Appeal Decision

Appeal Ref: APP/T2350/W/22/3304870

Land adjacent to Whittle Hall Farm, Moor Lane, Langho BB7 9JH

- The appeal is made under section 78 of The Town and Country Planning Act 1990 against a refusal to grant approval required under Schedule 2, Part 3, Class Q of The Town and Country Planning (General Permitted Development) (England) Order 2015.
 - The appeal is made by Mr Tom Procter against the decision of Ribble Valley Borough Council.
 - The application Ref 3/2022/0436, dated 29 April 2022, was refused by notice dated 22 June 2022.
 - The development proposed is described as: Proposed conversion/redevelopment of two agricultural buildings into two dwellings.
-

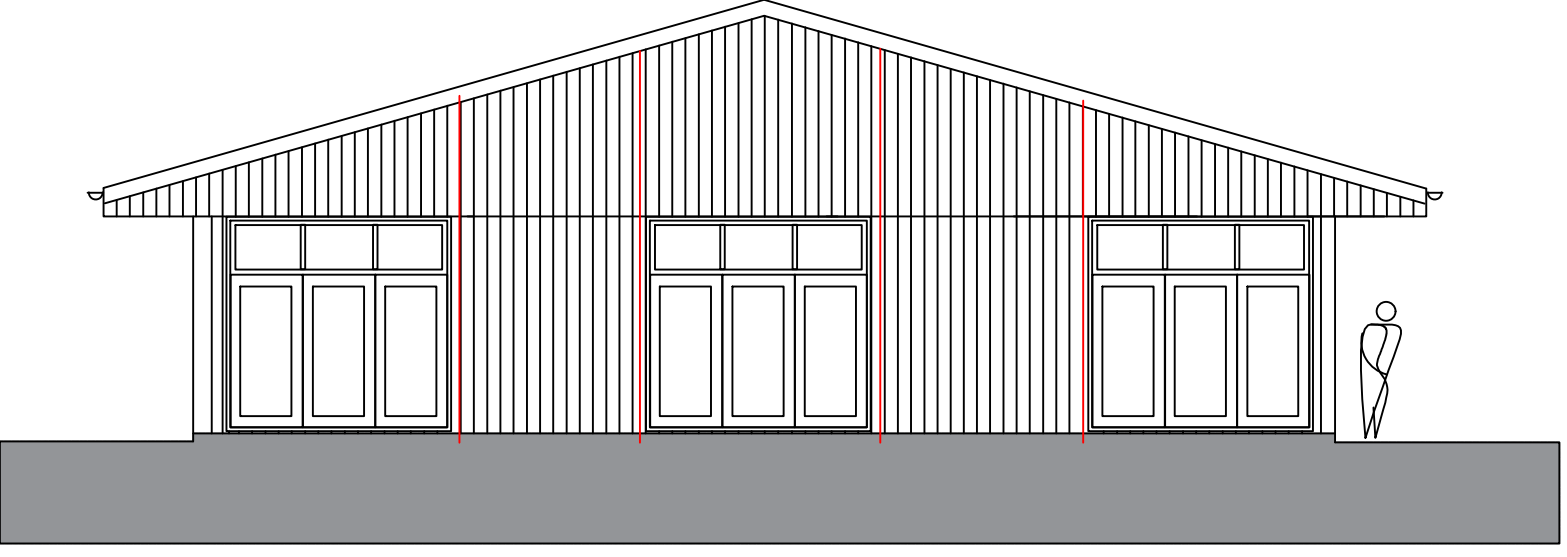
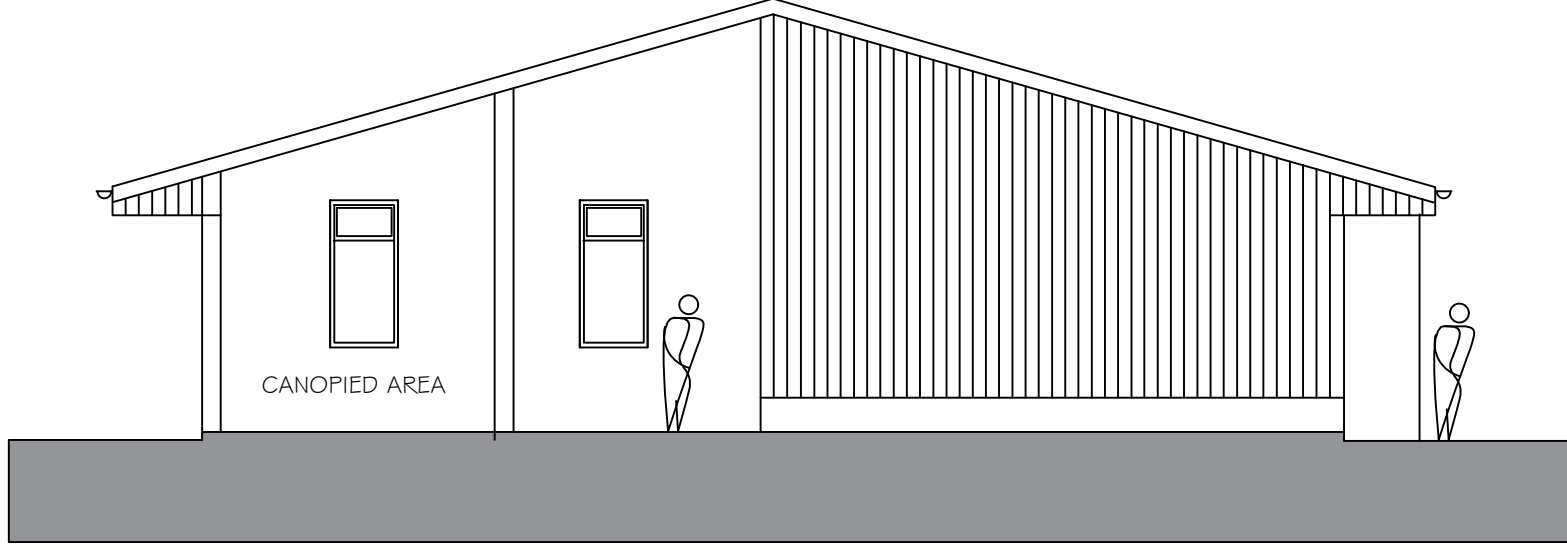
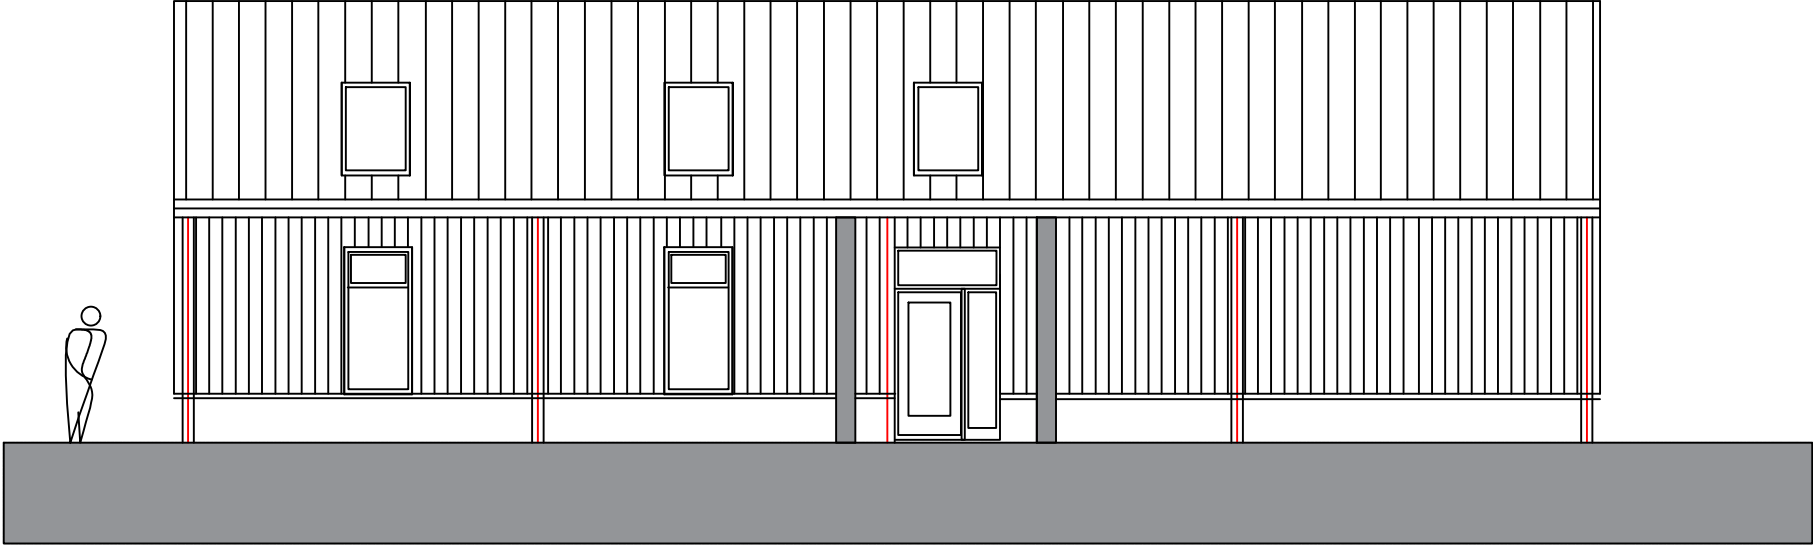
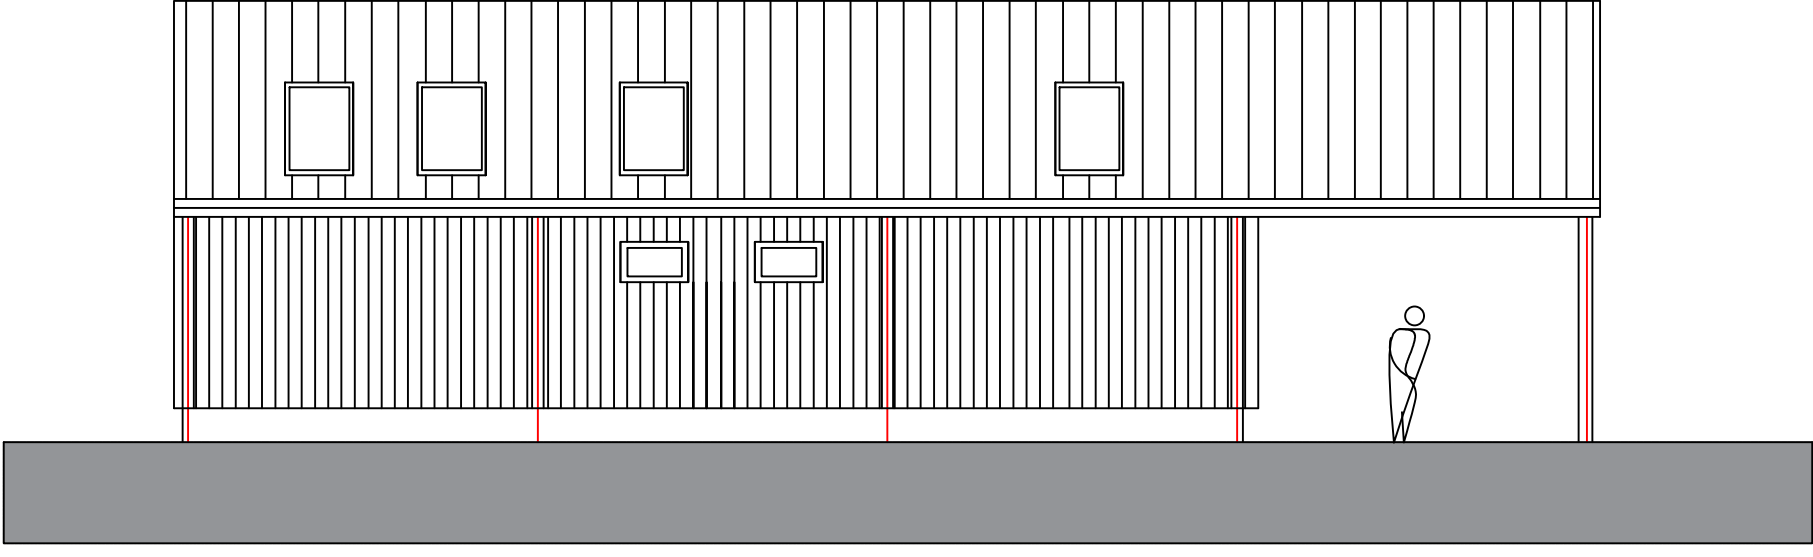
14. Whilst it is proposed to glaze the main openings on the north west elevation of the building at plot 1, the south east elevation would be completely reconfigured with a large open canopied section to one side as well as domestic proportioned openings. This elevation faces the road and is visible from the public right of way to the east. The proposed north east elevation facing the public right of way would feature three new openings of domestic proportions. The rooflights proposed would take a haphazard appearance and would not reflect the regimented positions of the existing rooflights.

drawing title:
EXISTING AND PROPOSED
BUILDING PLANS/ELEVATIONS
FOR PLOT 2

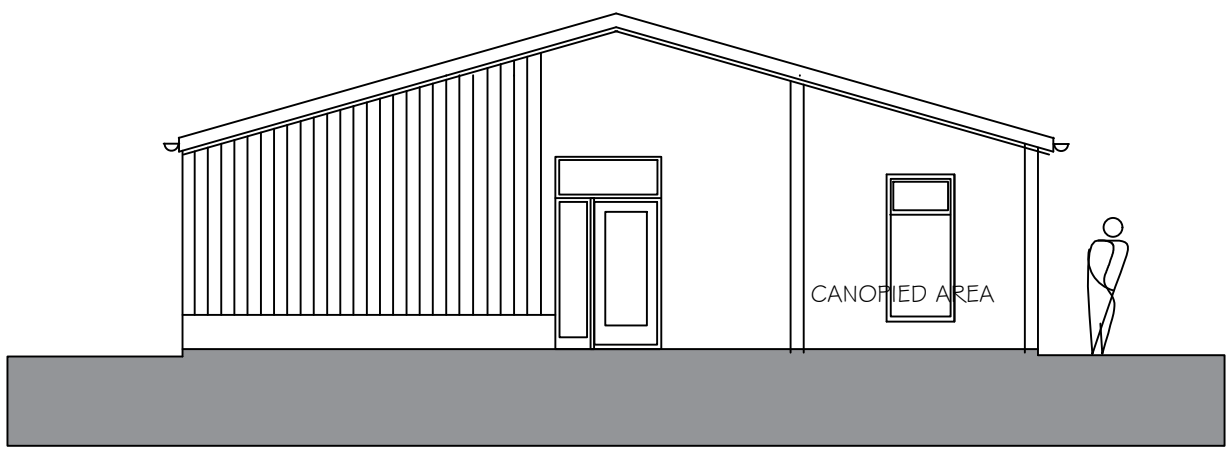
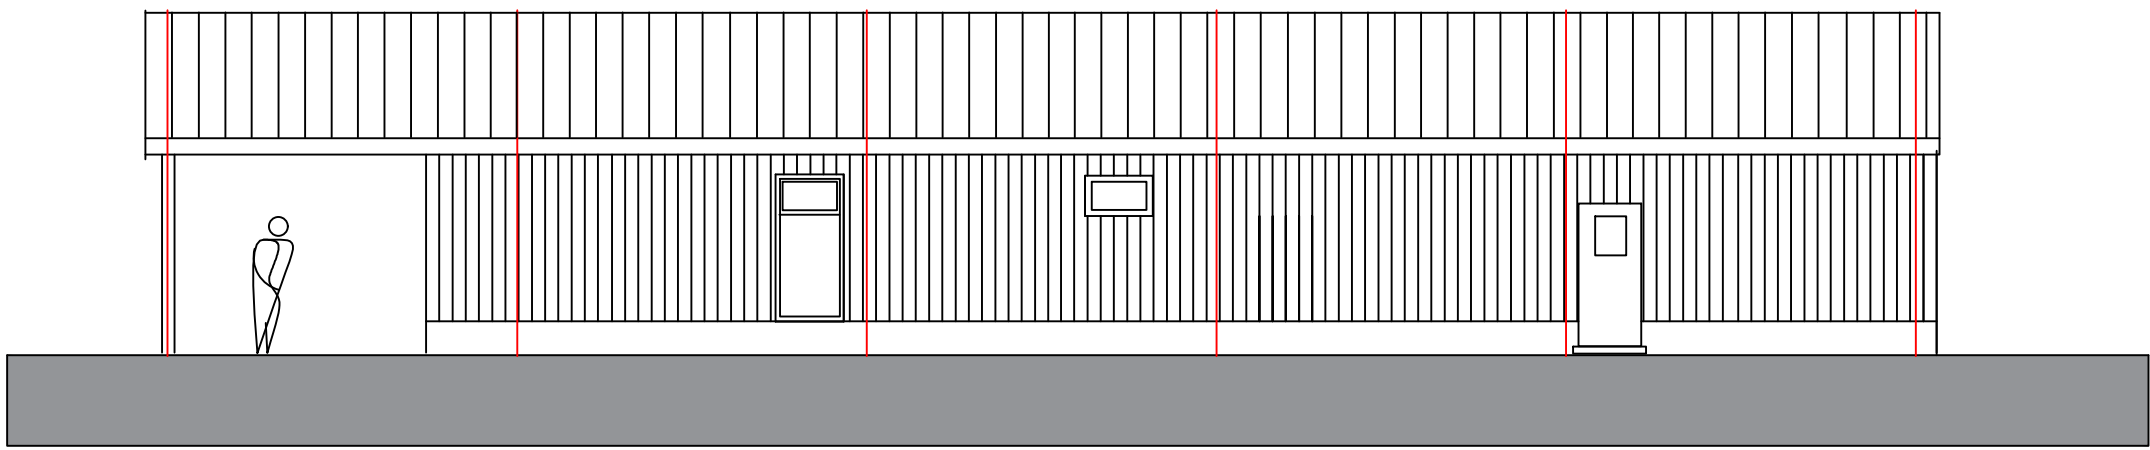
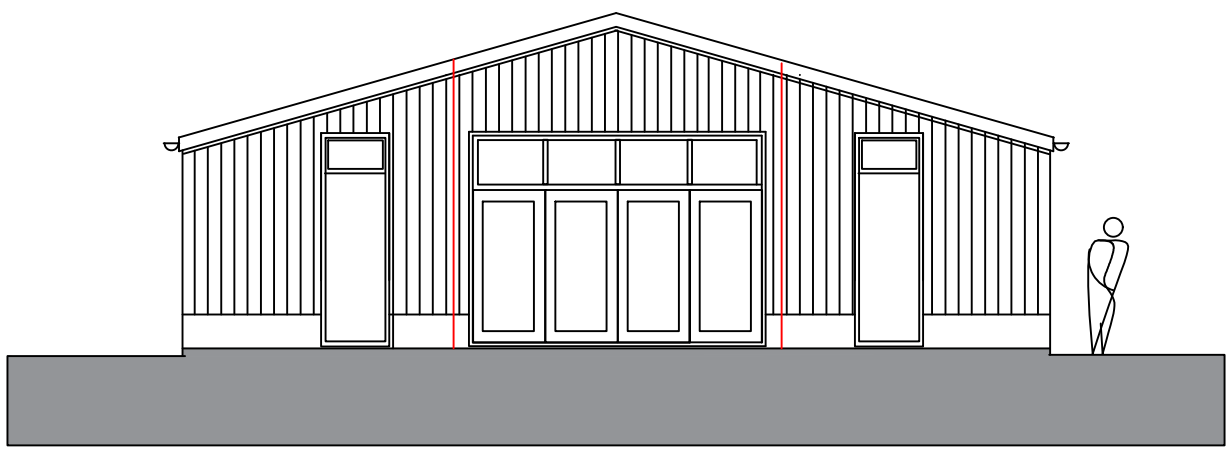
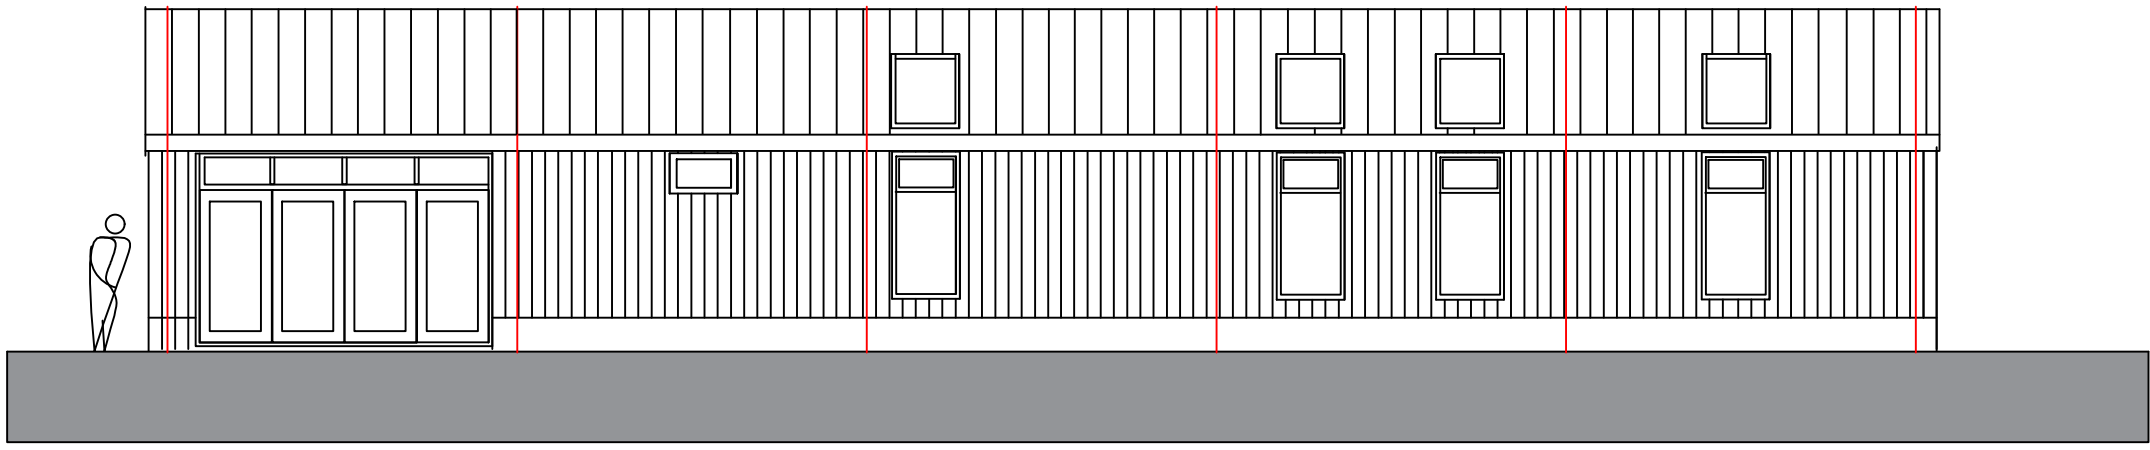
15. Similarly, the building at plot 2 also features extensive reconfiguration of openings, with six new openings to the south west elevation. Neither gable would reflect the scale and position of their existing openings. There would be new openings to the north west gable and the provision of another canopied section to the opposing gable. As with plot 1, the rooflights would be haphazardly arranged on the roof and would not reflect the existing regular arrangement.
